**From:** Clay Parrott  
**Sent:** Monday, December 29, 2025 10:19 AM  
**To:** Bradley Gasawski  
**Subject:** RE: SP-25-00012 Clear View - Notice of Application

**Subject:** SP-25-00012 Clear View - Notice of Application

**To: All Staff**  
**From: Environmental Health**  
**Date: December 29, 2025**  
**Subject: SP-25-00012 Clear View**

SHEET
 2
 OF
 3

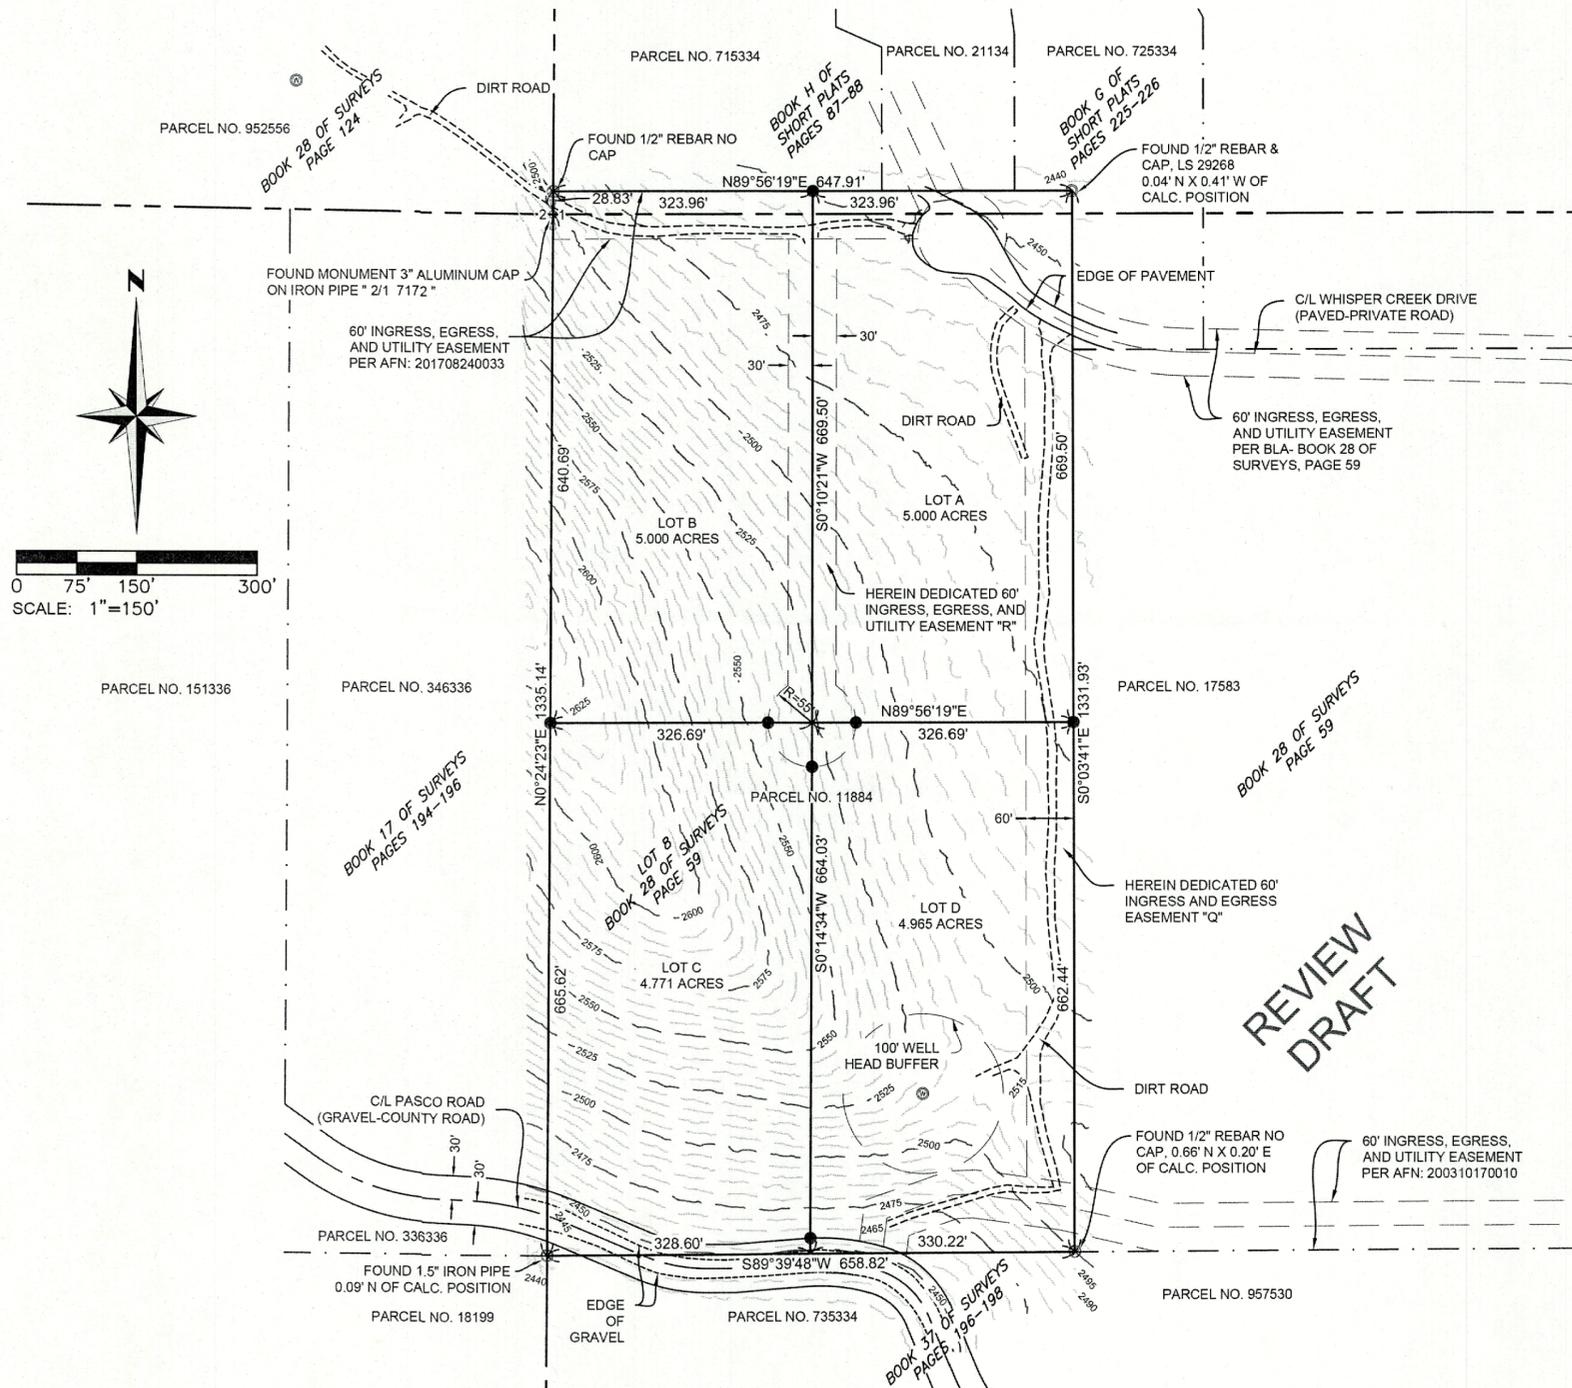
<b>Drinking Water</b>	<ul style="list-style-type: none"><li>• Supply water quality testing for bacteria / nitrates for existing well</li><li>• Supply well log for existing well if it is 10 years or older</li><li>• Supply 4 hour draw down test for existing well if it is less than 10 years old</li><li>• Supply shared well user agreements for both wells</li><li>• Individual Well Site Review application must be completed for newly constructed well</li><li>• Water supply protection zone of at least 100 foot radius for each existing or proposed well site</li></ul>
<b>Wastewater</b>	<ul style="list-style-type: none"><li>• Provide updated on site septic as-built verifying property lines are a minimum of 5 feet from the edge of the current mound system filter media and include reserve area location</li></ul>
